From: Sue Howell
Sent: 15 May 2014 15:55
To: Neil Crowther; Bernie Harverson [REDACTED]
Cc: Joe Russell-Wells
Subject: RE: BN/13/14 Landscaping

Comment from Greenspace regarding landscaping

Landscaping - Typical Plots

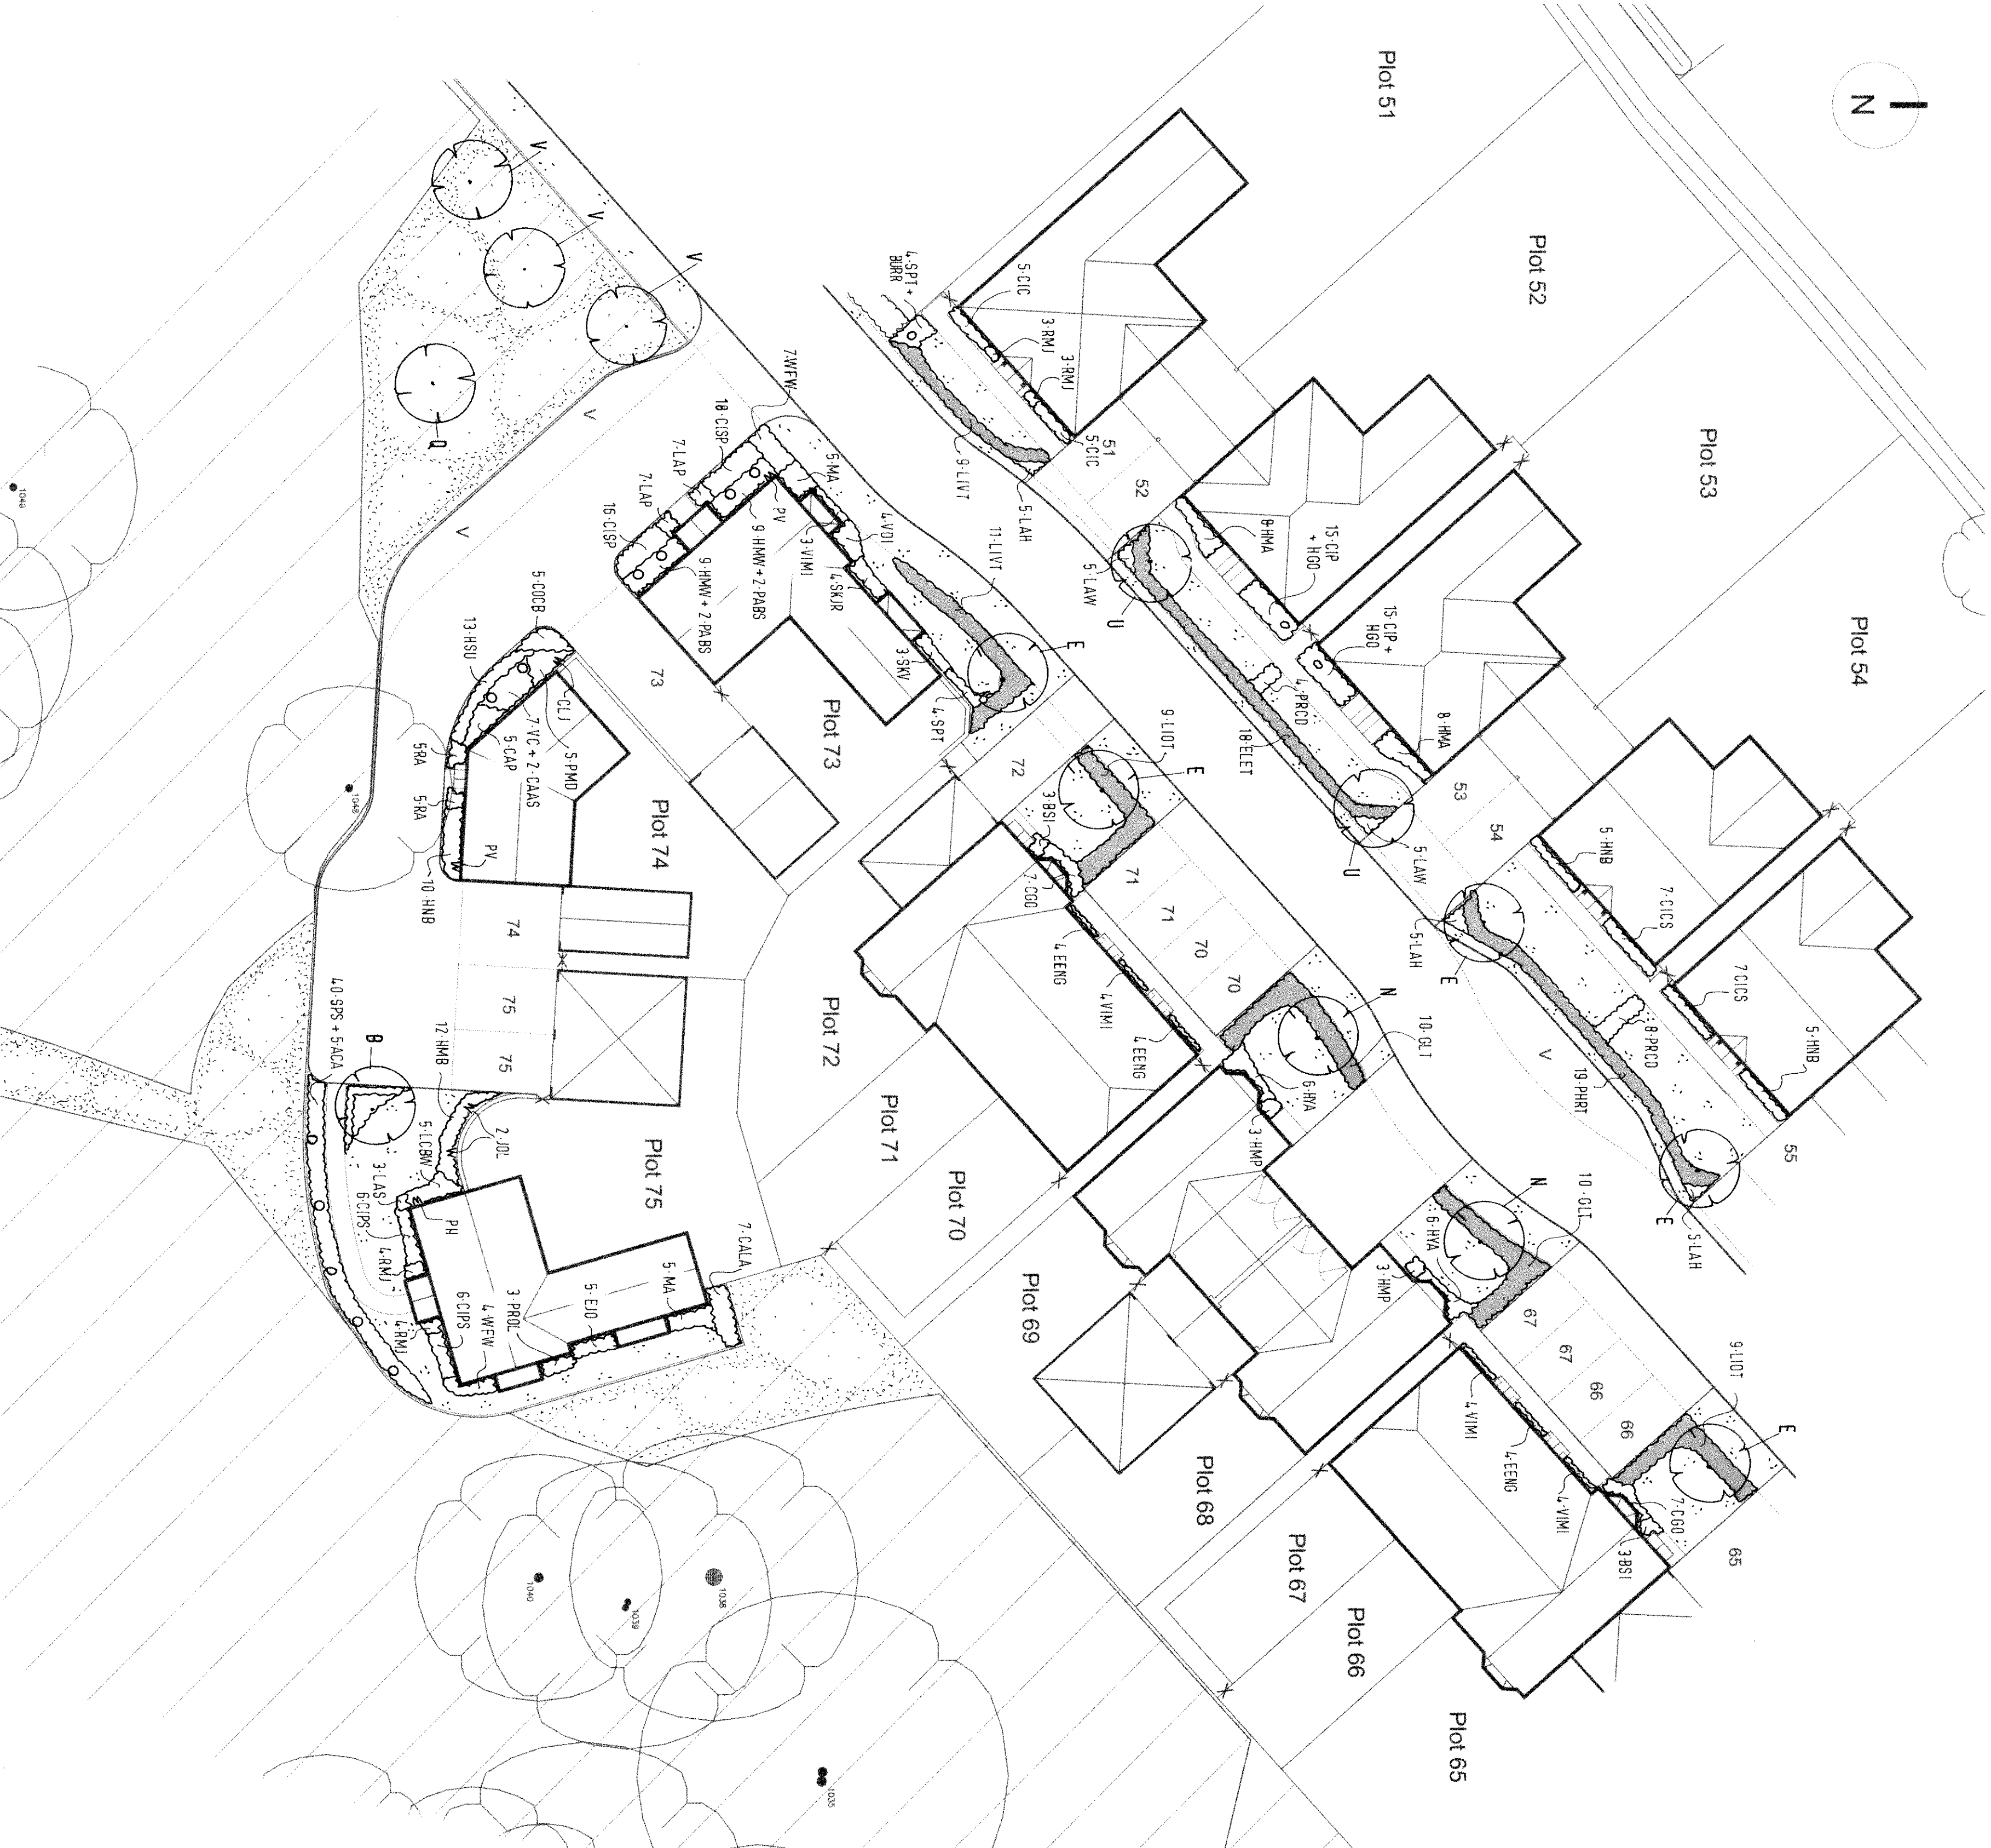
The landscaping detail issued is a comprehensive scheme which details species choice, densities and size at time of planting. The scheme submitted would be suitable for the locations indicated. The Public Open Space proposals does fit a broadly native woodland scheme in the trees, shrubs and hedging proposed. The species choice detailed is fitting for the location and provided the existing tree and shrub cover is protected throughout the works in accordance with BS 5837:2012 'Trees in relation to construction' and retained then the scheme proposed would be satisfactory.
